Recommendation Report for Planning Permission for Works or Extension to a Dwelling

REF NO: **AW/37/14/**

LOCATION: 18 Fish Lane
Aldwick

PROPOSAL: Two storey & chalet extension with dormer to front & rear single storey extension. Resubmission of AW/298/13

sheet 2 of 4

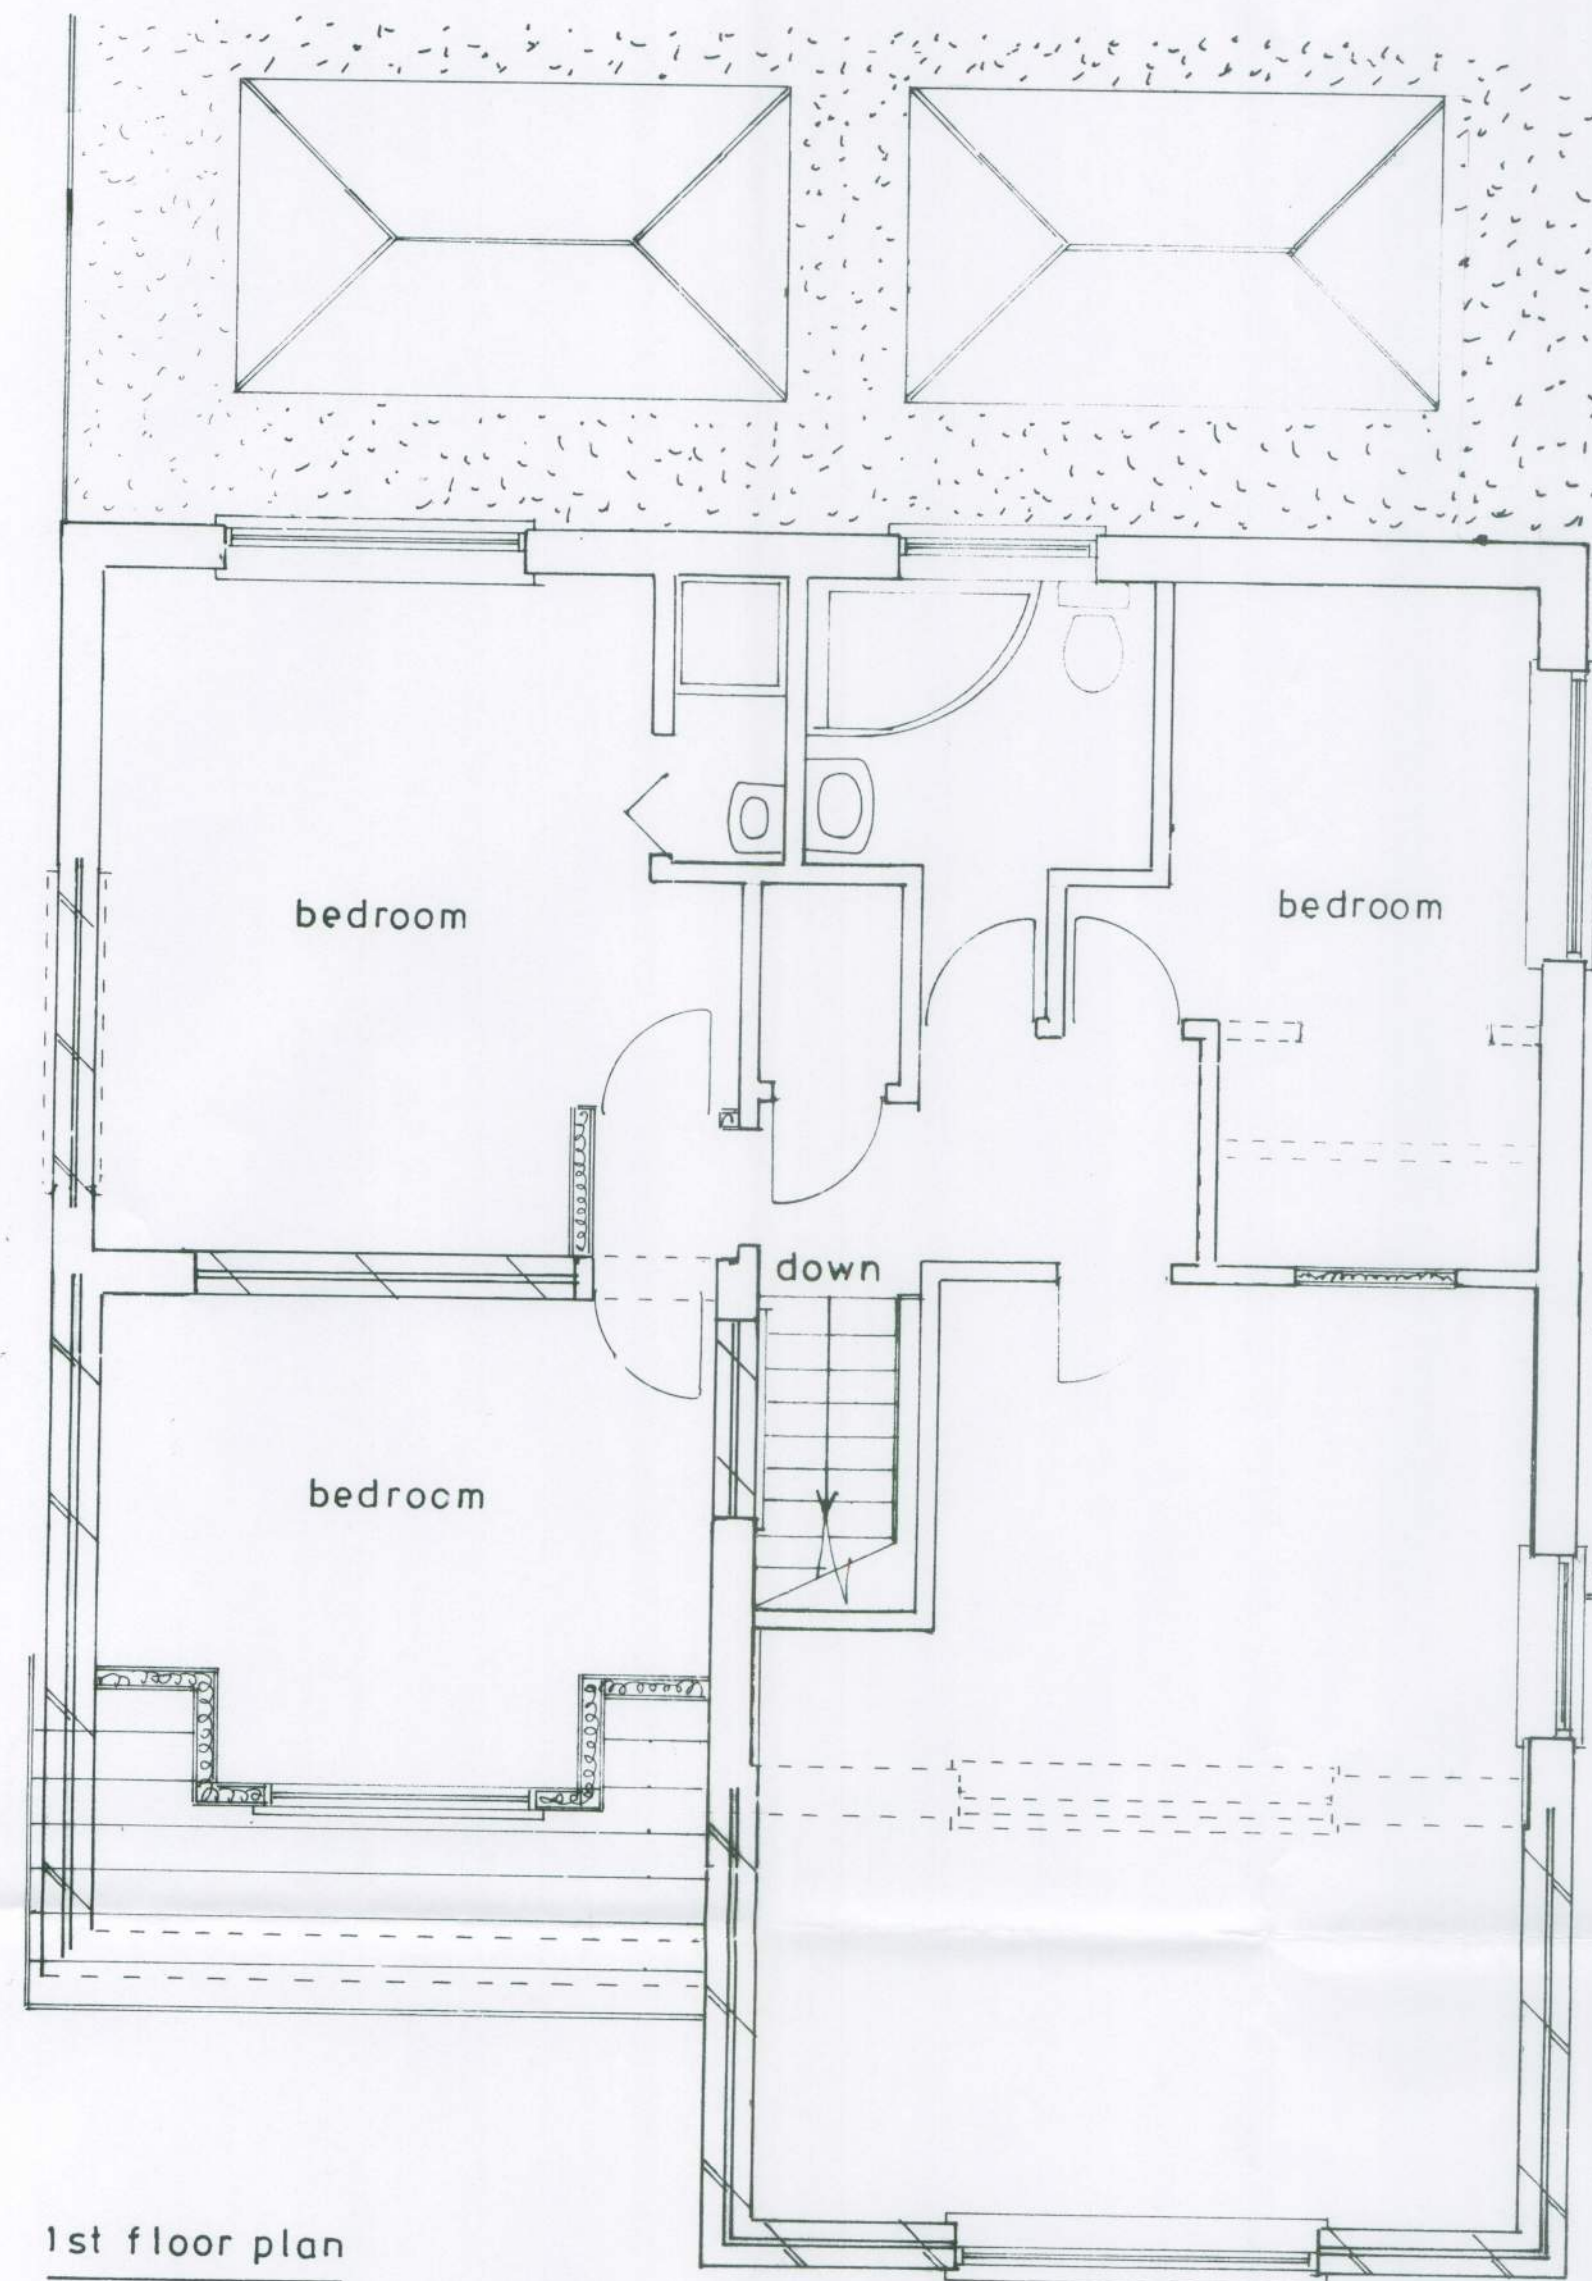
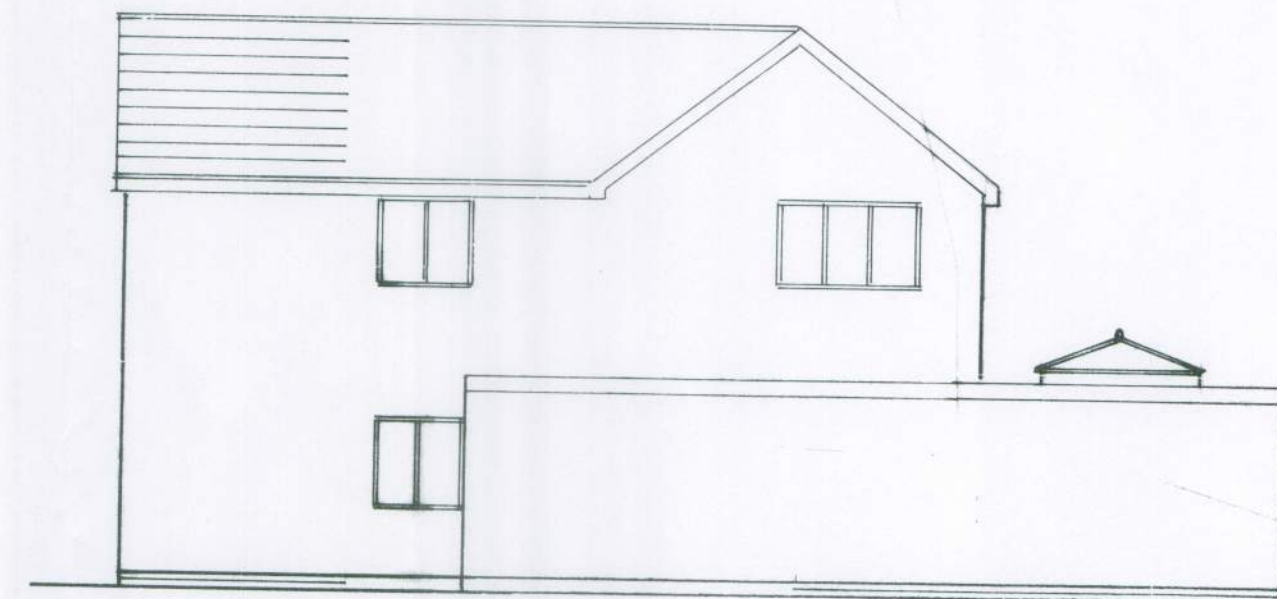
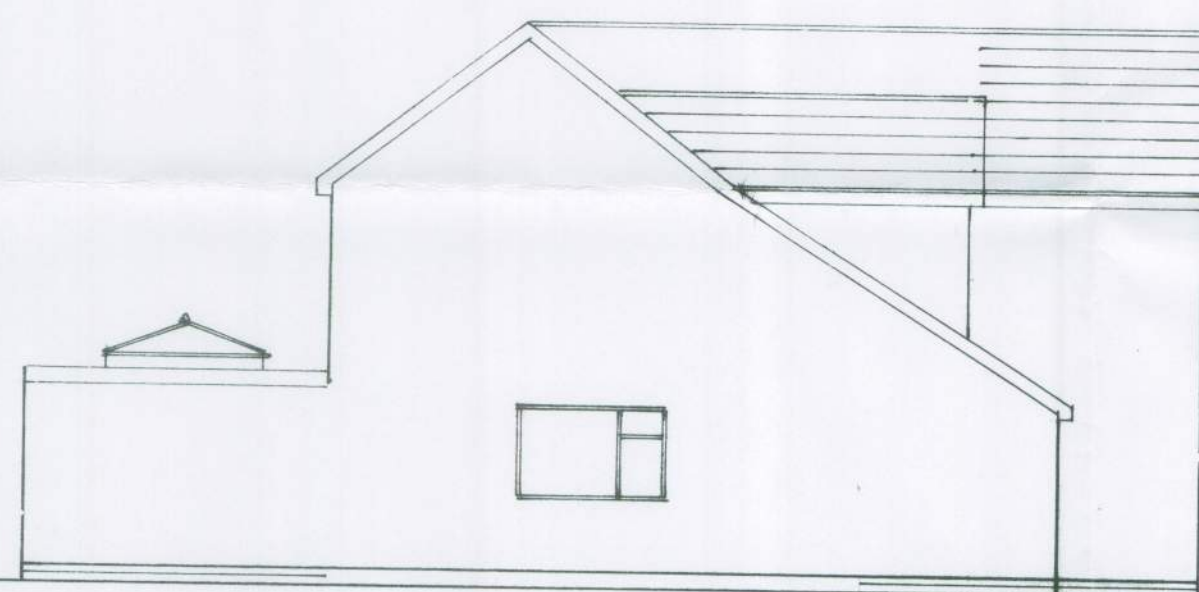
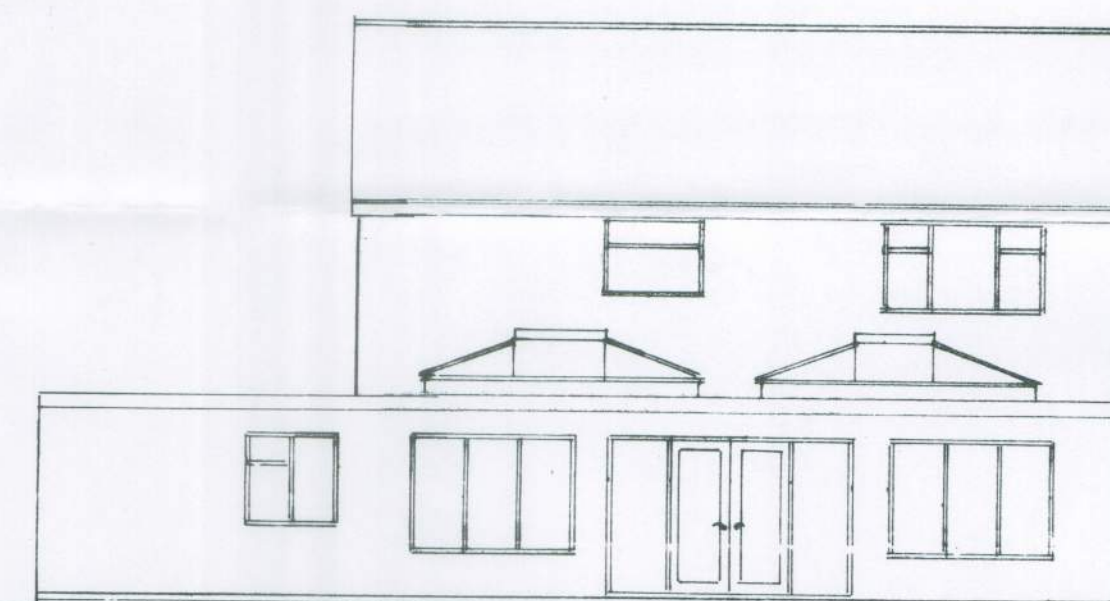
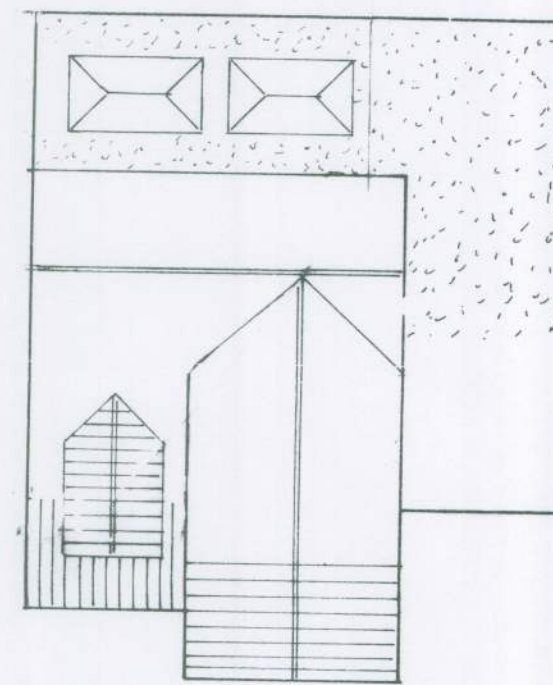
Members strongly objected to the application on the grounds that the planned extension does not relate sympathetically to and is not visually integrated with, the existing building in siting, design, form, scale and materials; that the extension comes too close to the side boundary and is unneighbourly and overbearing and that the extension compromises the established spatial character and pattern of the street. Therefore, Members agreed that the application is in direct conflict with Policy DEV19 of the Arun District Local Plan 2003. The application also conflicts with the Development criteria of Aldwick Parish Council's Parish Design Statement.

Development is no improvement on the previous scheme. To the west is a two storey building which has been constructed extremely close to the boundary and the proposed development would sandwich my property between the two massive developments. Front extension is well in front of current building lines. Development is not in keeping with the original features of the traditional Fish Lane concept, dominant to a neighbours presence and generally without consideration to others. Detrimental to property values.

The proposed two storey extension on the western side will be no greater than the existing width of the dwelling and will still retain a gap of 0.9m from the boundary. In view of its front projection it will be sited approximately 4m from the neighbouring property to the west No 20.

With adequate distance to this property it is not considered that the extension would be overbearing to neighbouring properties or create a loss of outlook. See conclusions section of the officers report for impact on neighbouring properties. Effect on the value of property is not a material planning consideration.

The plans now submitted comprise two extensions to the front which has reduced the overall height of the two storey element adjacent to the western side boundary. The property has a conservatory on the front western side and this is to be removed and the two storey extension with front dormer will be set back from the front flank wall of the dwelling leaving a visual break between the adjacent property No 20. The adjacent two storey element will be sited in the middle of the dwelling and will be no higher than the existing roof height with a front projection of 3m with gable feature that will replicate the style of the existing gable. There is a garage on the eastern side with store and the single storey side extension which is sited approximately 0.375m from the eastern side boundary will link up with the rear extension having a rear projection of 4m.

The neighbouring two storey property to the east No 16 comprises two flats and is set forward of the dwelling and the proposed front extension will be sited approximately 4.5m away. There is a balcony on the front west side of the dwelling at first floor level and there is a single storey flat roofed structure on the rear adjacent to the boundary, part of which is garages. There are no windows on the side elevation of the two storey element and the single storey rear extension

would project out to the same amount as the adjacent neighbouring structure. In view of its height and the absence of windows on the side elevations of the front and rear extensions it is not considered that the extensions would be overbearing or create any direct overlooking to the occupiers of the neighbouring flats.

The neighbouring property to the west is a two storey chalet property has a front bay window and window on the east side elevation that serve the living area and an obscure glazed dormer window on the side elevation fronting No 18. The proposed front extension will be sited approximately 4m from this property and will project forward by approximately 2m. With the roof line sloping away from this property it is not considered that this would be of overbearing nature or create a loss of outlook. This property has a single storey flat roof extension that is sited to the eastern side boundary with No 18 and projects out into the rear garden by approximately 5m. It is not considered that the rear single storey extension in view of its height and rear projection of 4m would be readily visible above this extension to the occupiers of No 18.
